Submission of Non-Material Amendment ('NMA') Application: Rothbury STW

Further to our recent discussions, we are pleased to submit on behalf of our client, Northumbrian Water Limited, a Non-Material Amendment ('NMA') application in respect of planning permission ref. 21/00498/FUL at Rothbury STW, Northumberland, NE65 7PL.

"Extension of existing sewage treatment works including erection of operational structures, kiosks, fencing and upgrades to track and hardstanding"

**Rothbury STW I&D  
New PST Elevations  
Planning Application**

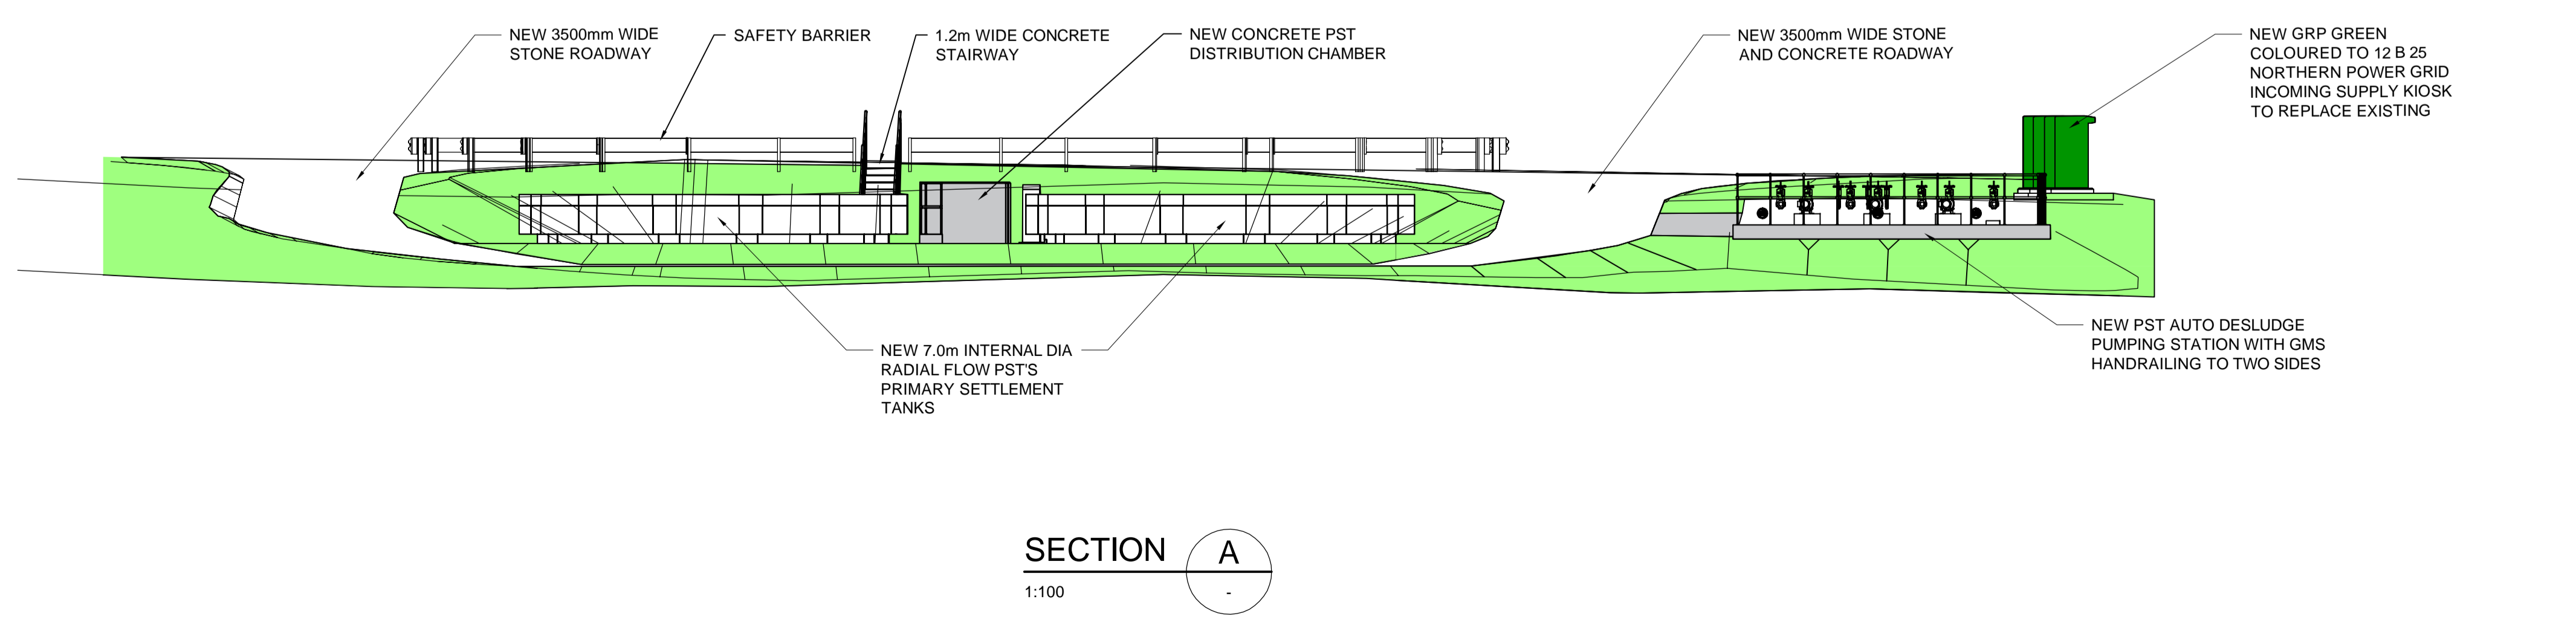
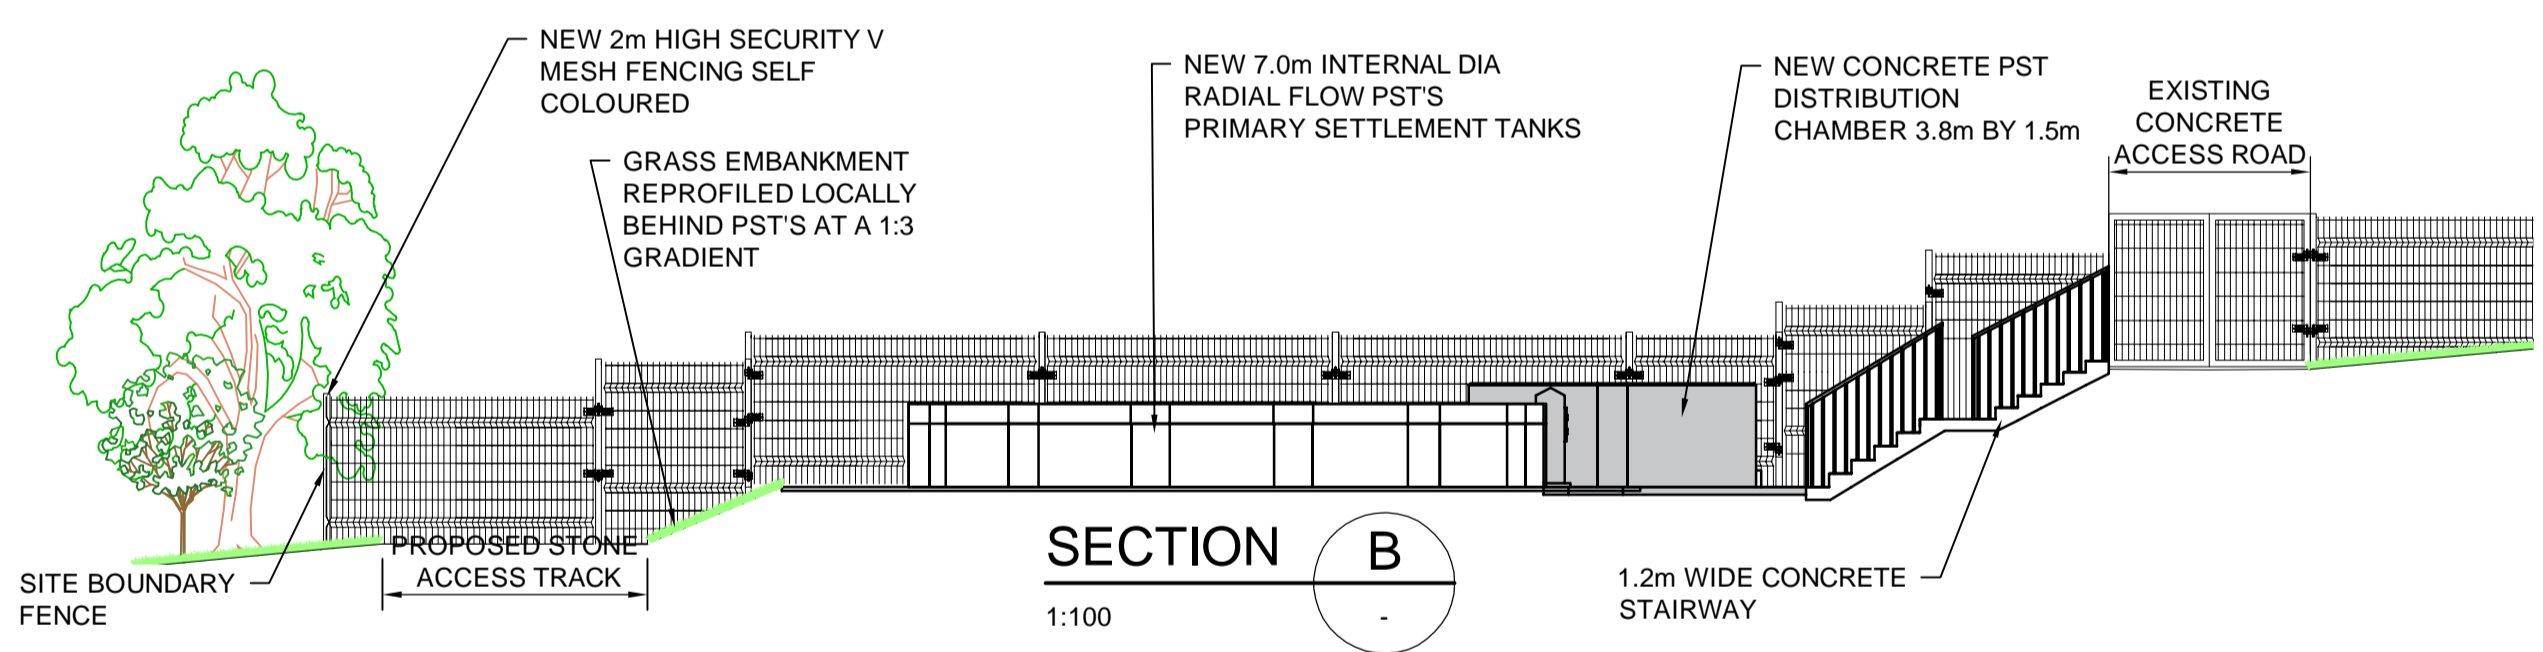
- Relocation of the Final Effluent Sampling Chamber to be adjacent to the HSAF Plant;
- The provision of a vehicle safety barrier along the road above the Primary Settlement Tanks (PSTs);
- Rationalisation of road turning circle radii; reduced area of concrete hardstanding at the PSTs; and reduced internal diameter of the new PSTs from 7.1m to 7.0m;
- The requirement for a new Incoming Power Supply Kiosk (internal dimensions 2100mm long by 750mm wide by 1800mm high) adjacent and to replace the existing kiosk for an increased power supply from NPG;
- The MCERTS flow meter chamber will comprise a manhole with open-mesh decking instead of a rectangular chamber with access cover; and
- Minor changes to proposed Finished Ground Levels and slopes.

Rothbury STW I&D
New MCC Kiosk Plan and Elevation
Planning Application

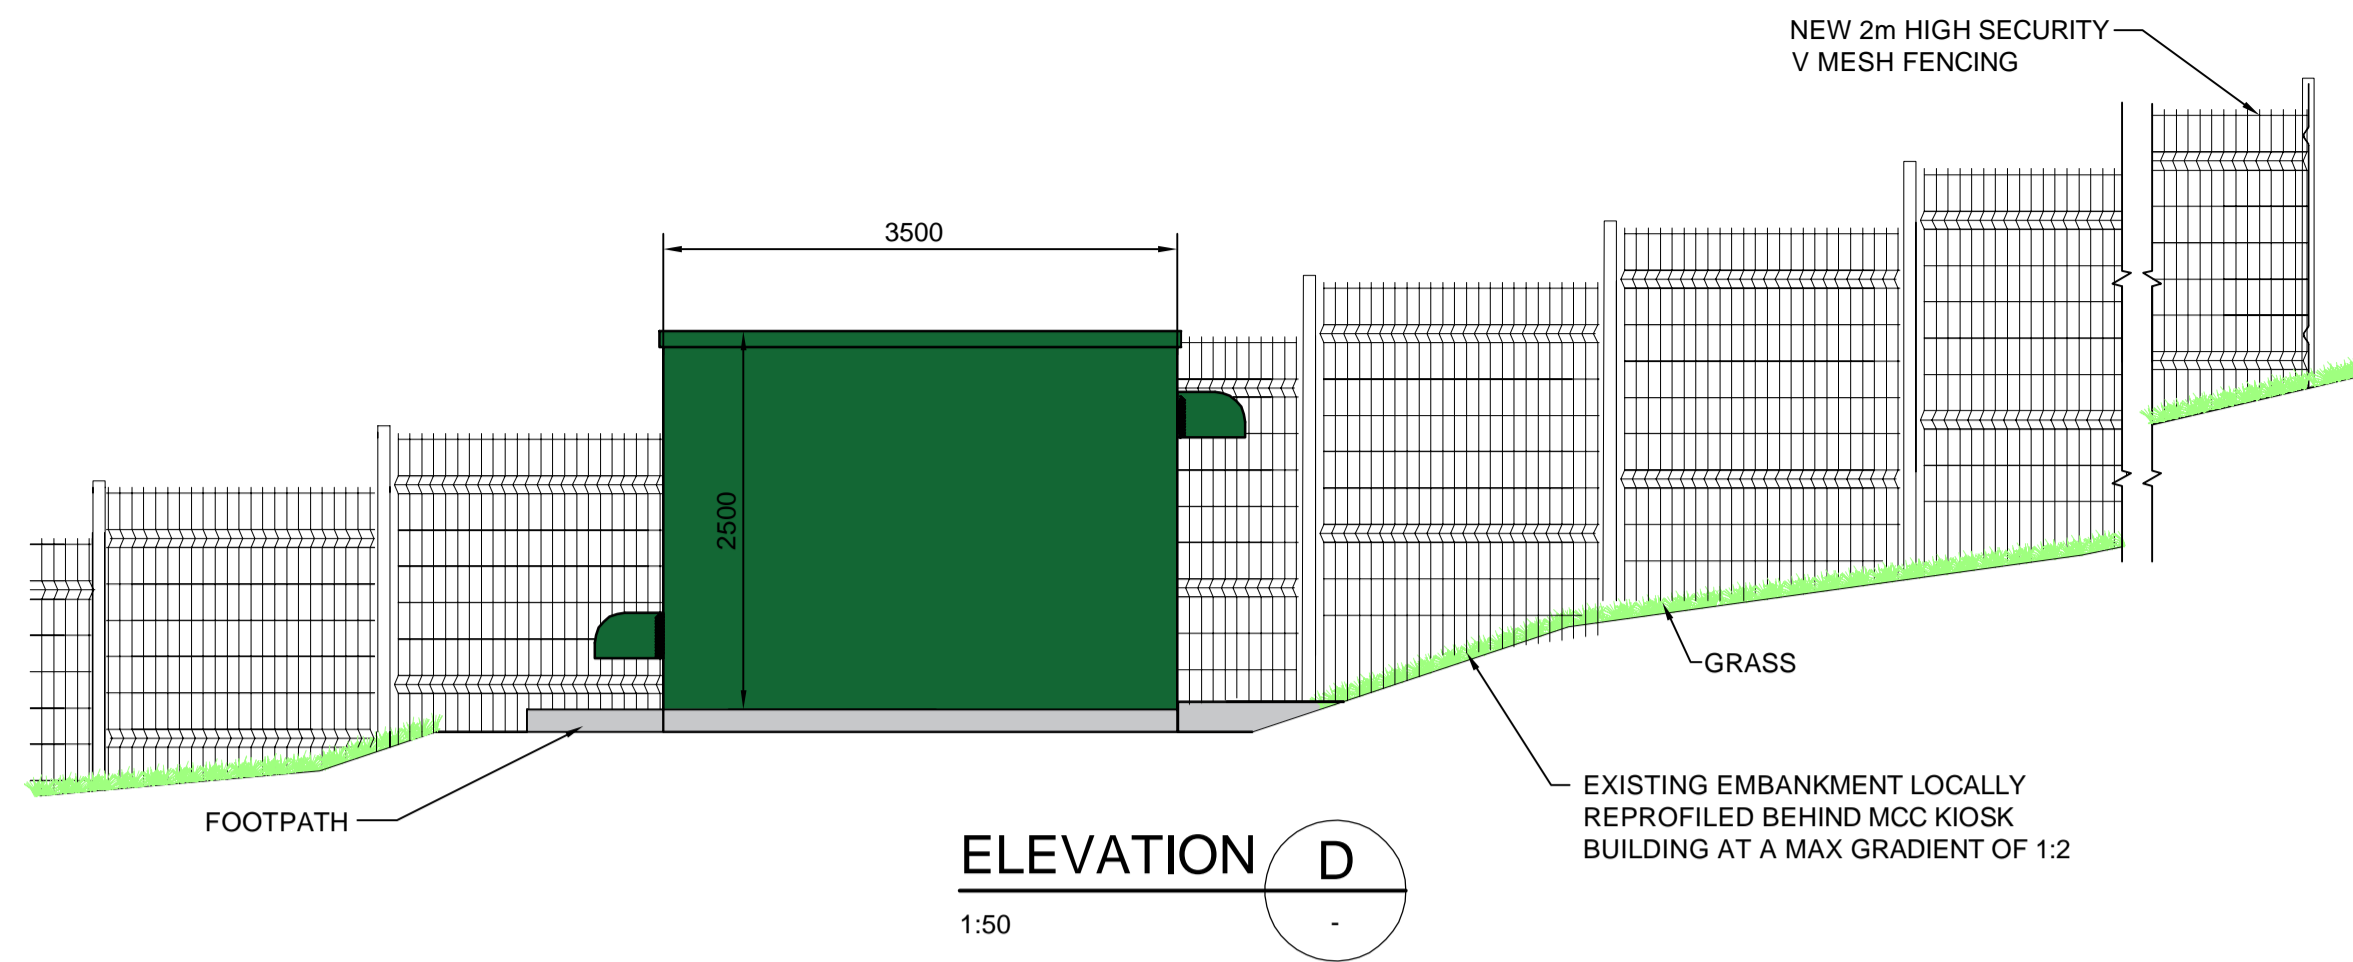
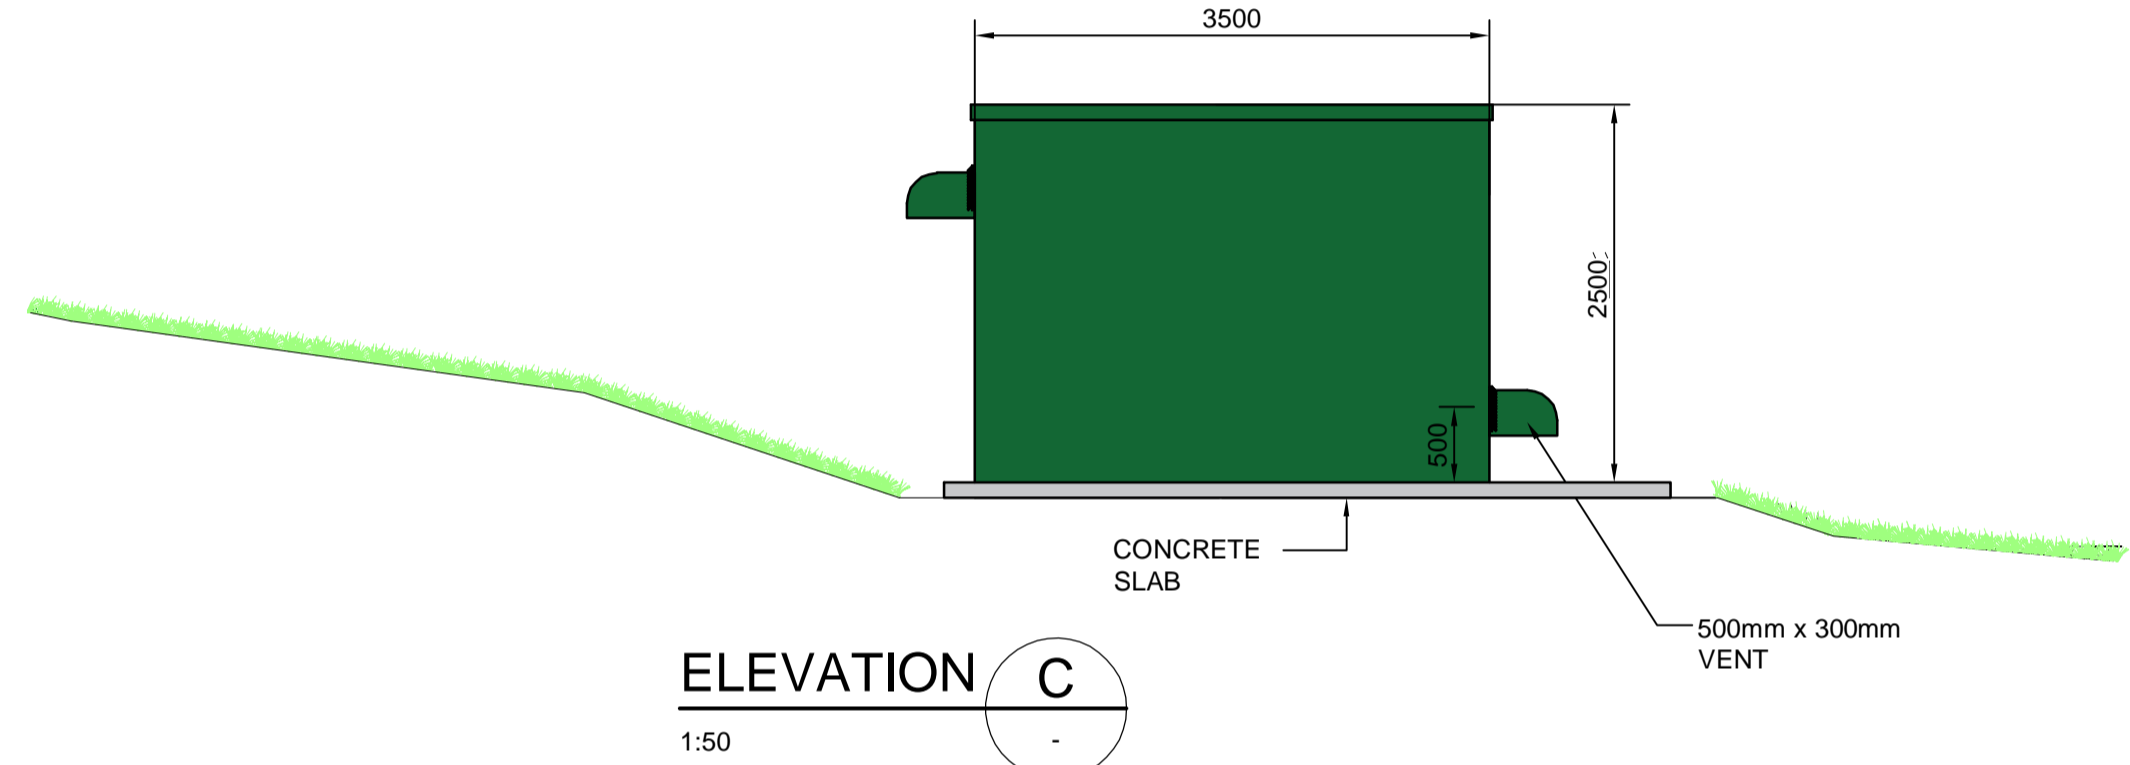
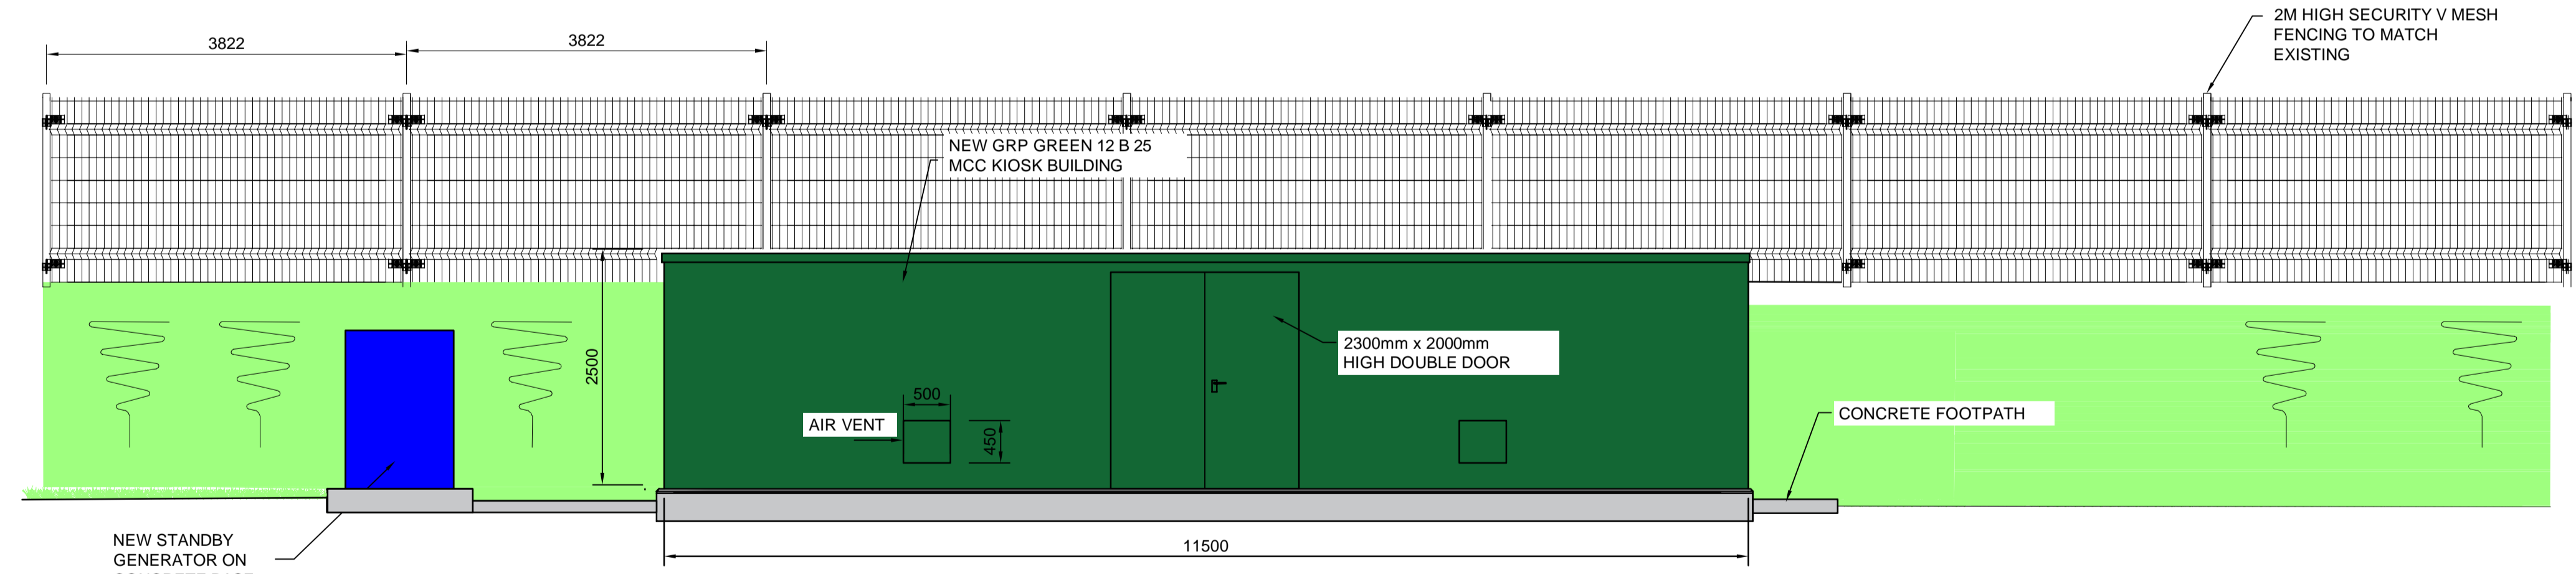
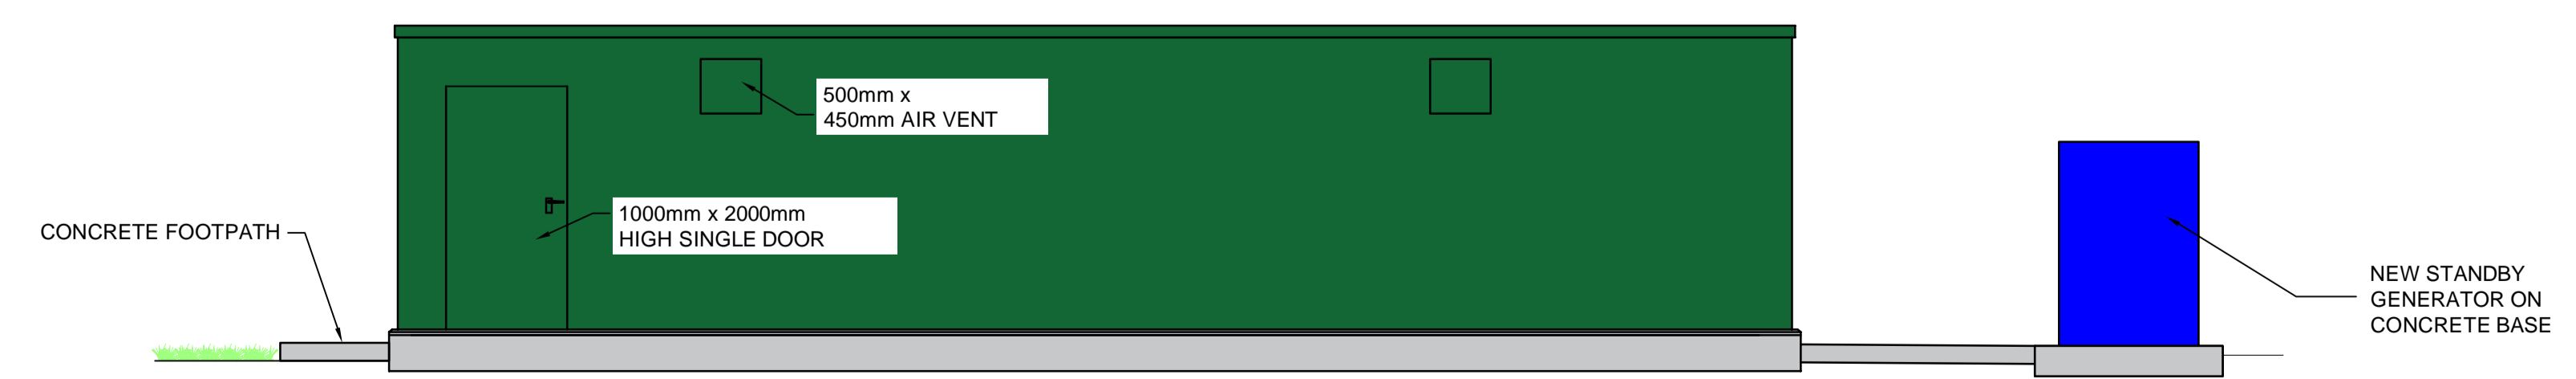
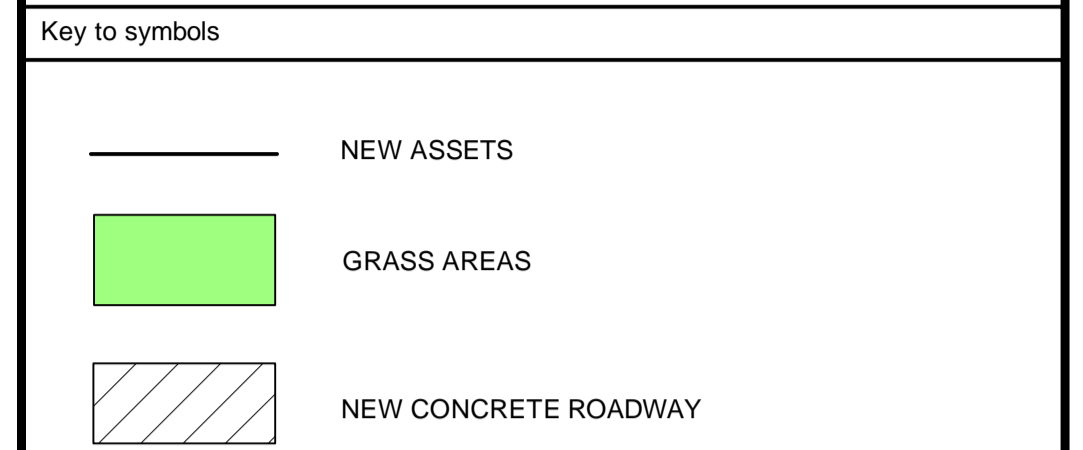
Since planning permission was granted, a number of non-material changes have been made to the design of the STW extension to optimise its future operational performance. Notably, these include a shorter MCC building kiosk (11.5m instead of 12.6m); and the switch in position of the Motor Control Centre ('MCC') Building and the Tertiary (HSAF) Treatment Plant.
